City of Albuquerque Stormwater Construction Site Inspection Report

ESC File No.	C09E011B	Project Name:	Bedrock at The Trails		
NPDES Id. No.	NMR1005SI	Location:	9300 Woodmont Ave. NW		
9/28/2023	Owner	Contractor			
Operator	Bedrock ABQ Investors, LLC (La Terra Development, LLC.)		LT Building Corp.		
Contact name & title	Lauren Boyd Chief Legal Officer		William Leahy President		
e-mail	laurenb@laterradev.com		williaml@ltbuildingcorp.com		
Contact Phone #	310-552-0065		310-552-0065		
COA Inspector	Doug Hughes		Start/End Time:	9am/11am	
Construction Phase:	Cleared, blasting, and grading				
Type of Inspection:	Regular	Storm Event	Past Storm Event >0.25"	311/Complaint	Follow Up
Weather at time of inspection?	Clear		Temperature:	~ 83	
Estimated date of last storm 0.25" or greater	9/13/2023

BEDROCK DRAINAGE MANAGEMENT PLAN

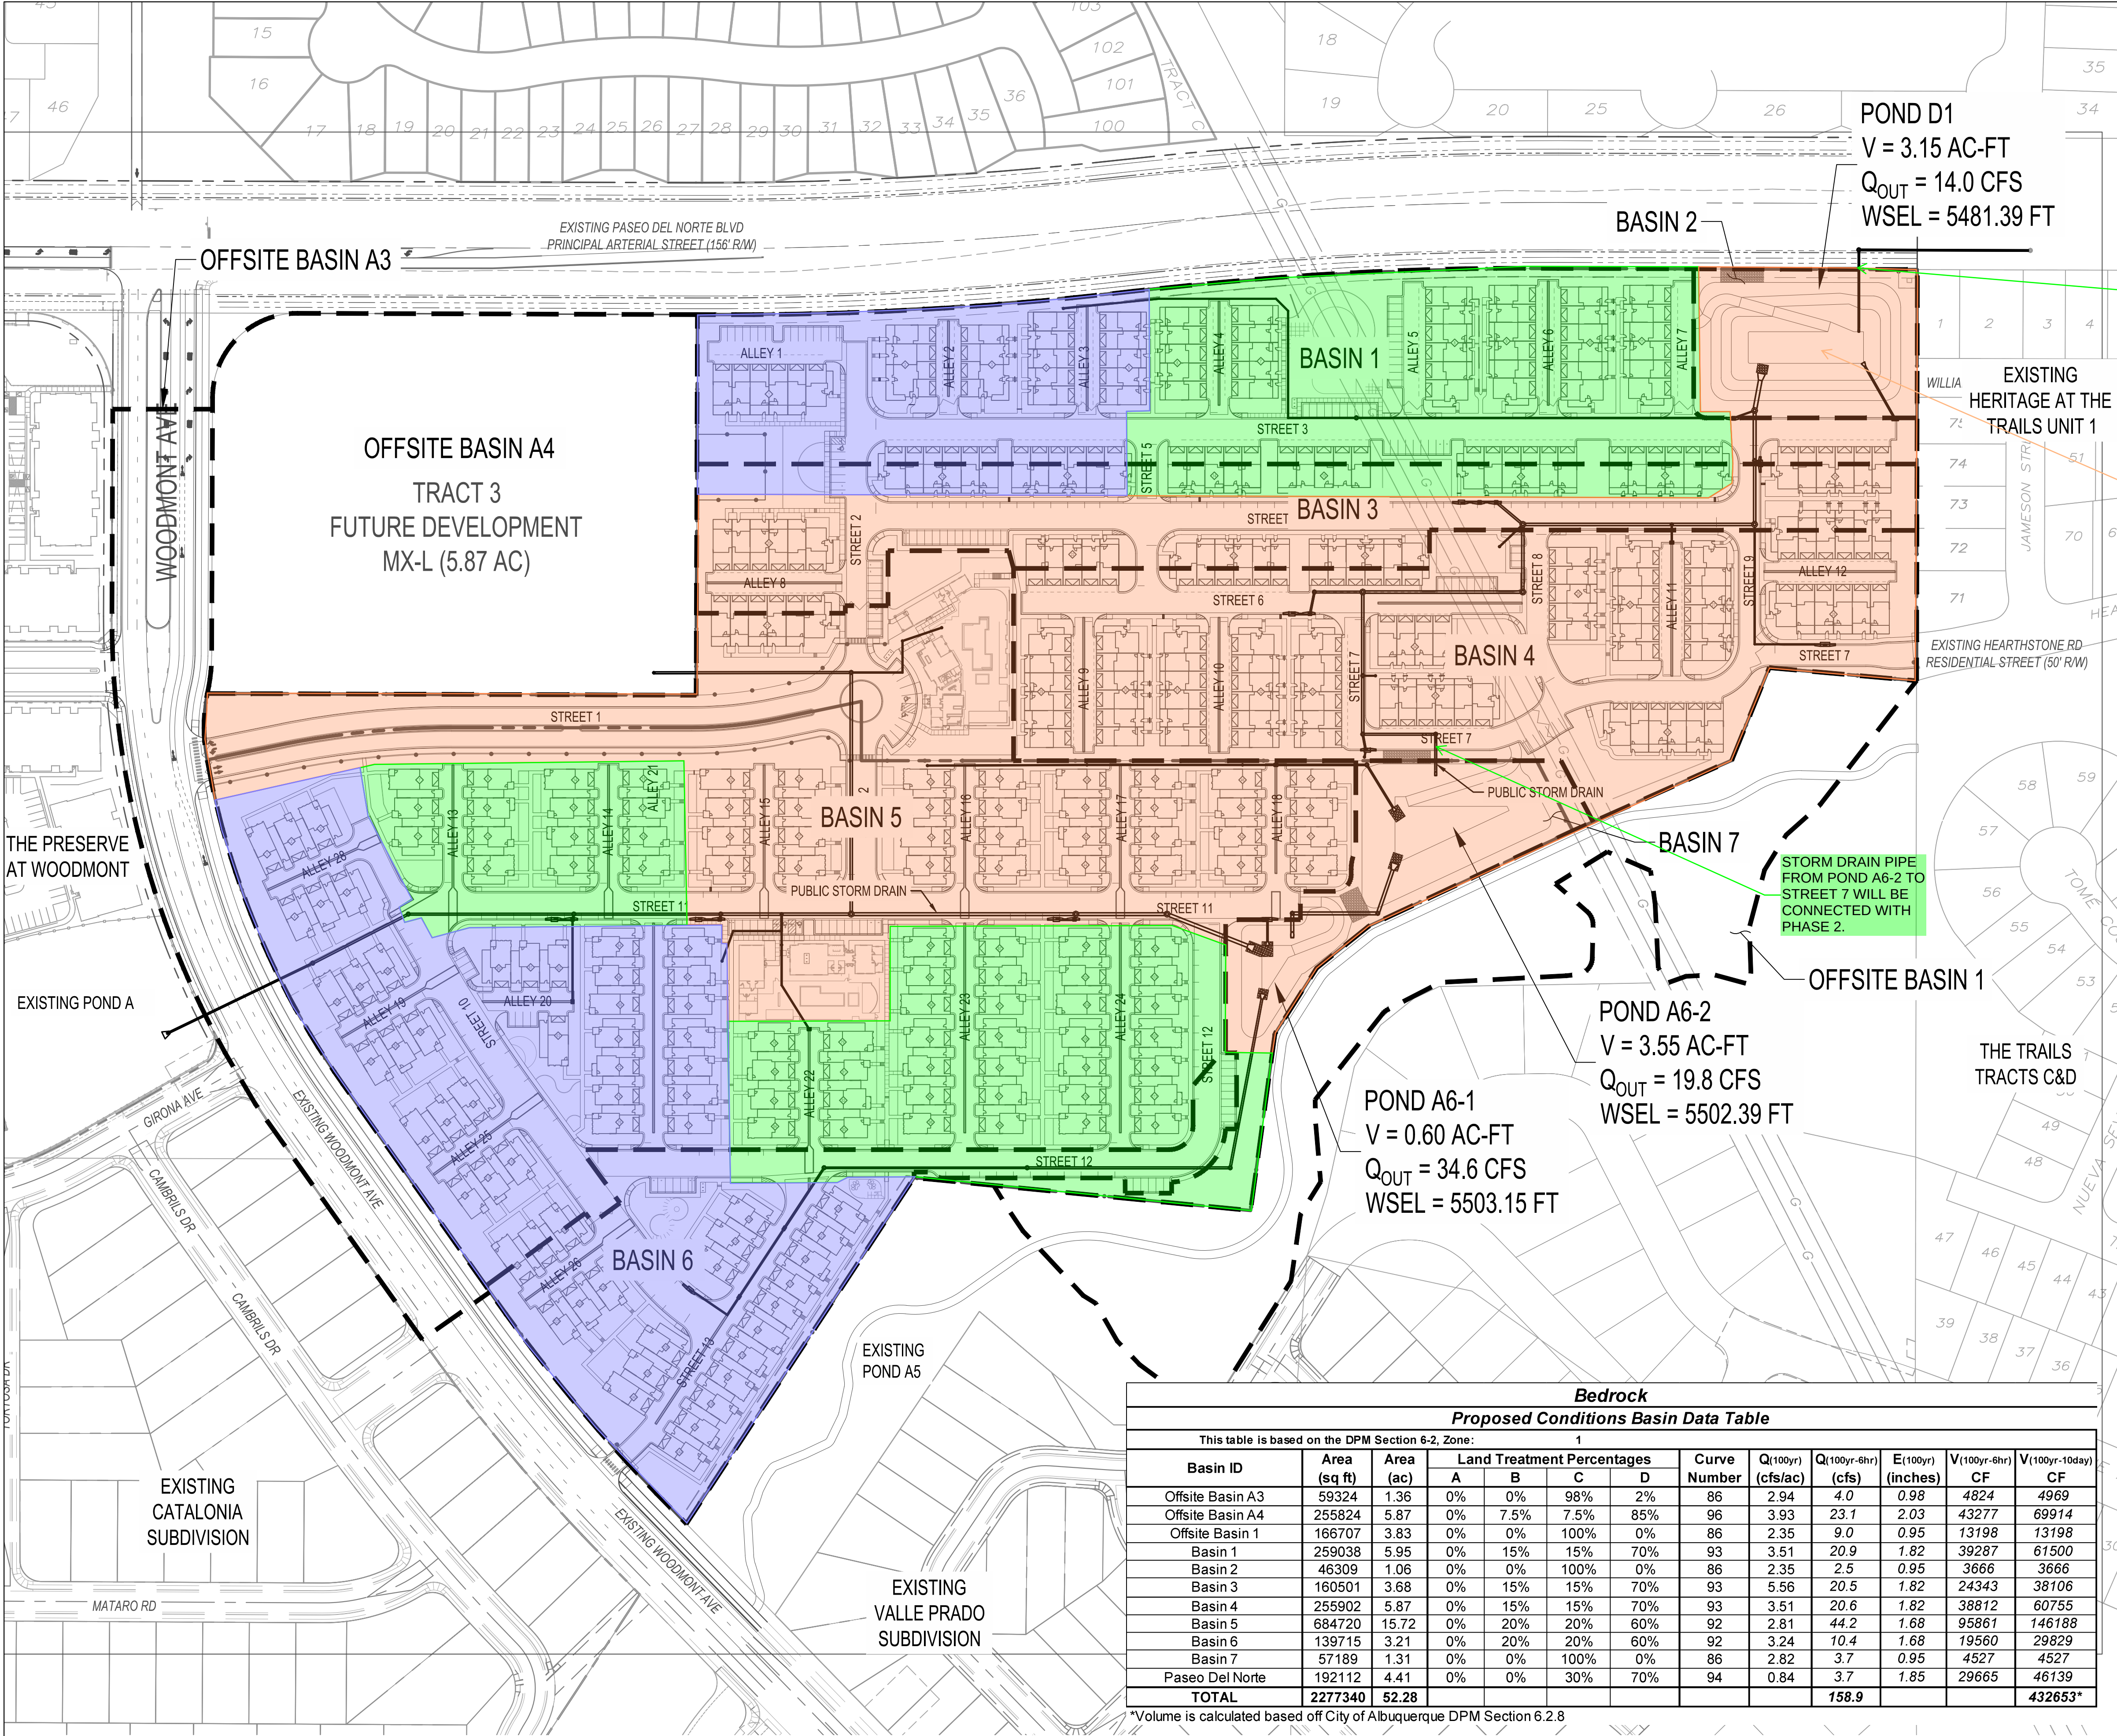
Item Number	Deficiency/ Corrective Action			
1	NOI - The east half of Tract 3 has been cleared and graded without obtaining coverage under the Environmental Protection Agency's (EPA's) Construction General Permit (CGP) in violation of CGP 1.4.3 and without an ESC Plan and NOI approved by Albuquerque's Stormwater Quality (SWQ) Section in violation of Ordinance § 14-5-2-11. Required Mitigation: The owner Tract 3, PV Trails Albuquerque, LLC., must obtain CGP coverage from the EPA in accordance with part 1 of the CGP, and he must submit the ESC Plan and NOI to Albuquerque's SWQ Section for review and approval in accordance with Ordinance § 14-5-2-11.			
2	SWPPP - The SWPPP was not up-to-date in violation of CGP 7.3. The SWPPP certification for Bedrock ABQ Investors LLC., the owner of Tracts 4 & 5, is missing in violation of CGP G11.2. and the NOI is inaccurate and imprecise. The NOI and SWPPP certification is missing for Tract 3 in violation of CGP 7.2.11 and CGP G11.2. Required Mitigation: Correct the NOI for Bedrock ABQ Investors LLC. and file an NOI for the owner of Tract 3. Include copies of each operator's NOI and SWPPP certifications in the SWPPP per CGP 7.2.11 and CGP G11.2.

3	BMPs . Sediment-laden stormwater has been discharged through at least three holes in the silt fence into Tract OS-2. due to a lack of maintenance of the perimeter controls in violation of CGP 2.1.4. Required Mitigation: you must ensure that all stormwater controls (BMPs) are maintained and remain in effective operating condition during permit coverage per CGP 2.1.4. If at any time you find that a stormwater control needs routine Maintenance, you must immediately initiate the needed maintenance work and complete such work by the close of the next business day.
